PLANNING AMENDMENT

H16/0393/03/A1

Amendment: Landscaping amended
(Dwg. no. 5781L-03 Rev L)

St. Norberts Church, St. Thomas's Road, Spalding, Lincolnshire

drawing
**PROPOSED GROUND FLOOR PLAN
+ LANDSCAPE PROPOSALS**

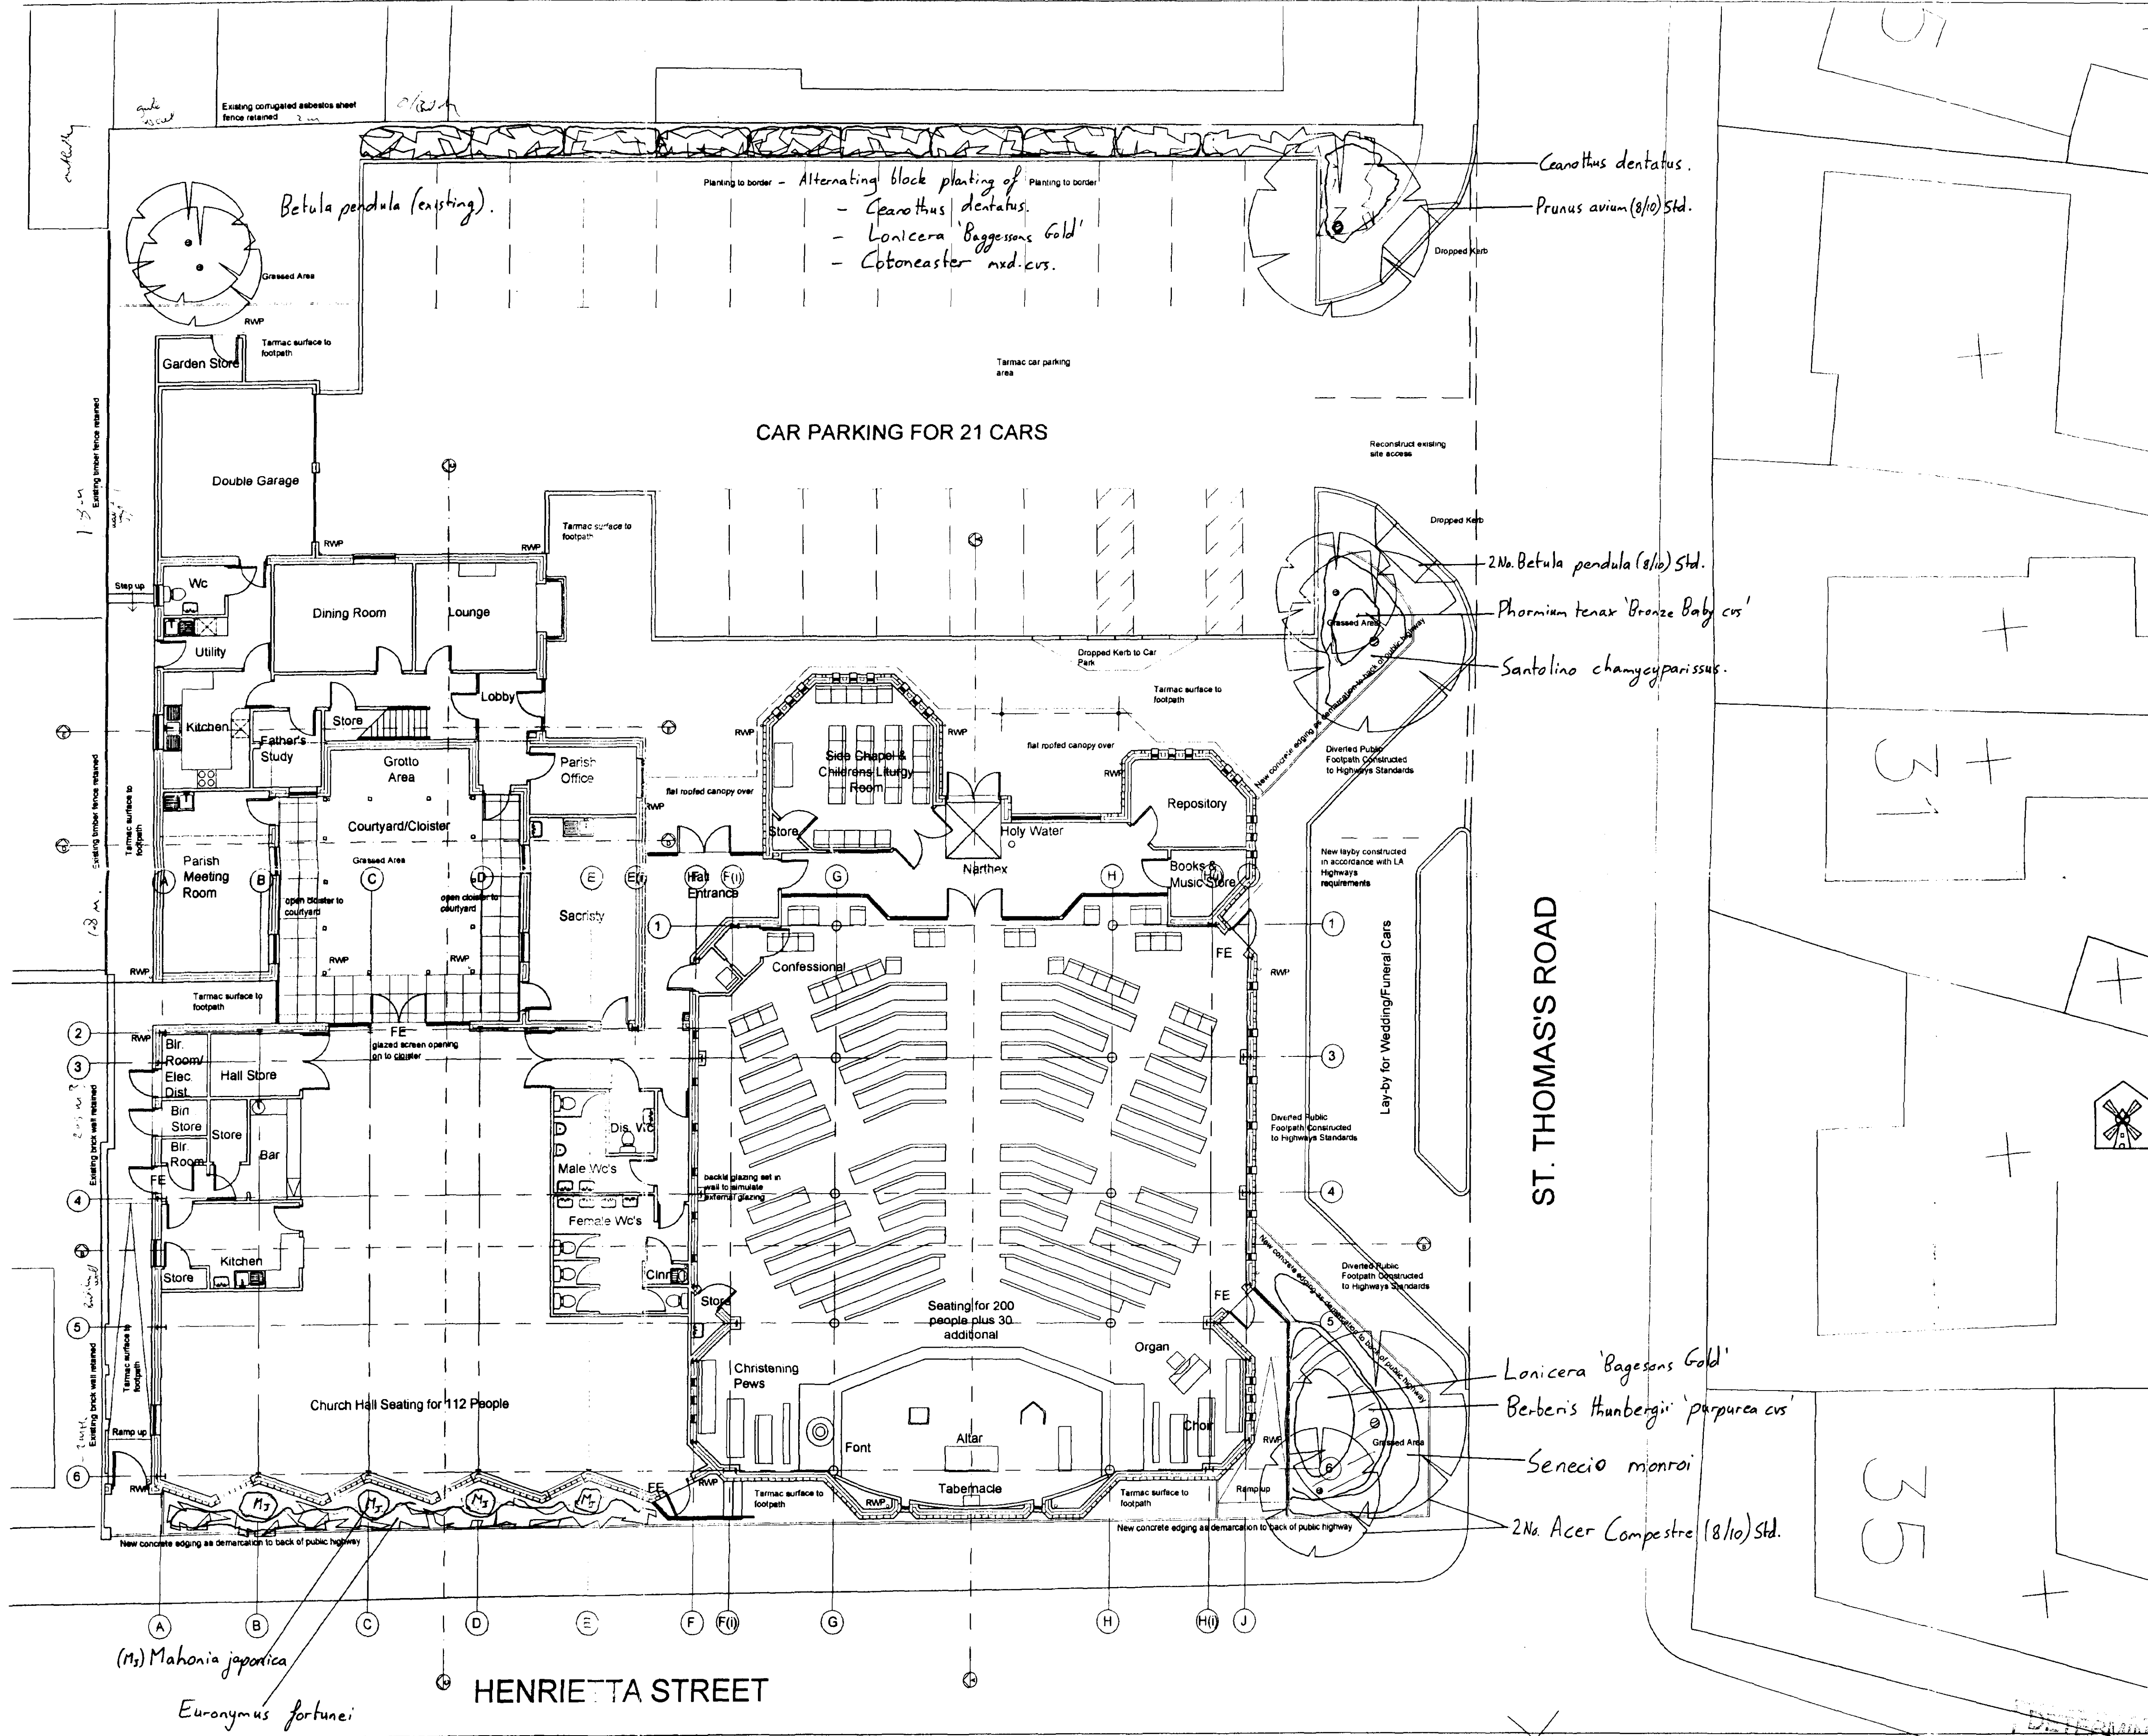
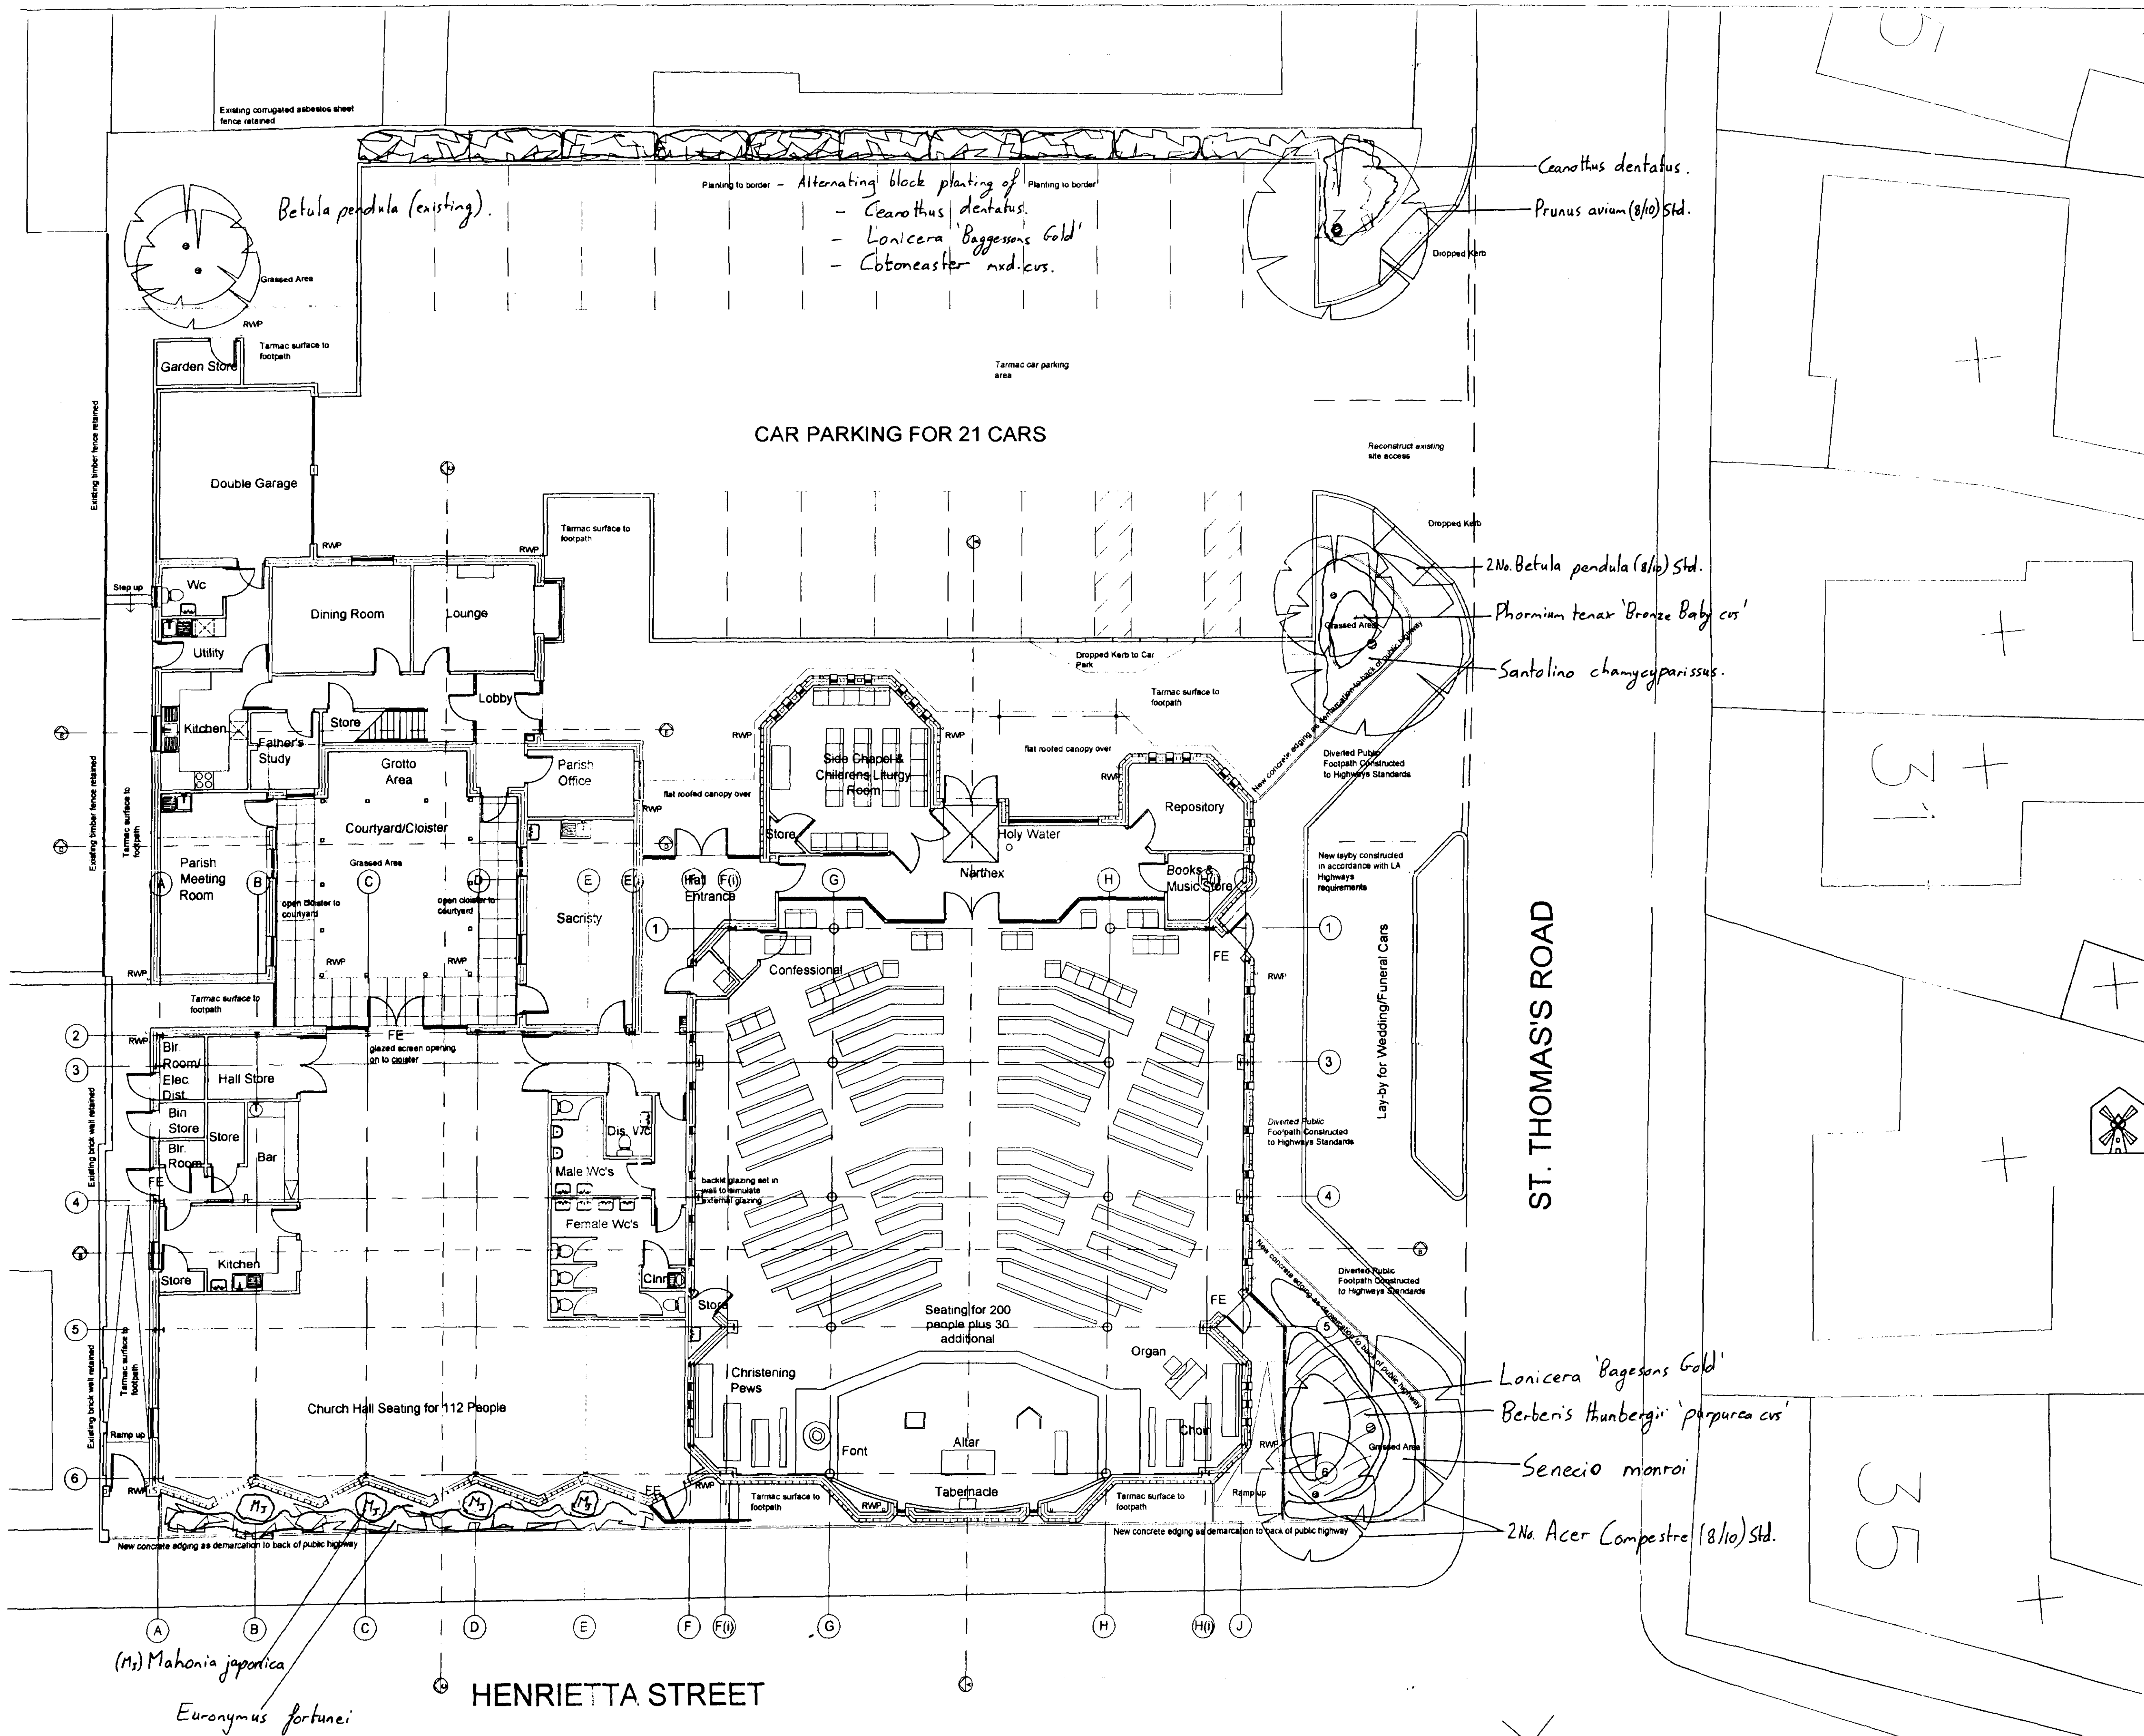
Further to our submission of landscape proposals of 21 March 2003, as required by Condition 2 of the Grant of Planning Permission and your subsequent Approval Notice of 20 May 2003, copies enclosed for ease of reference, we have been informed that due to the ground conditions on site the concrete foundations bordering Henrietta Street have had to be increased in width. We are further advised by Millview Nurseries that as a result of this any proposed planting in this area is likely to be difficult to sustain. We would therefore propose that the area of planting highlighted on the enclosed drawing is omitted and replaced with hard landscaping and to match the footway construction adjacent.
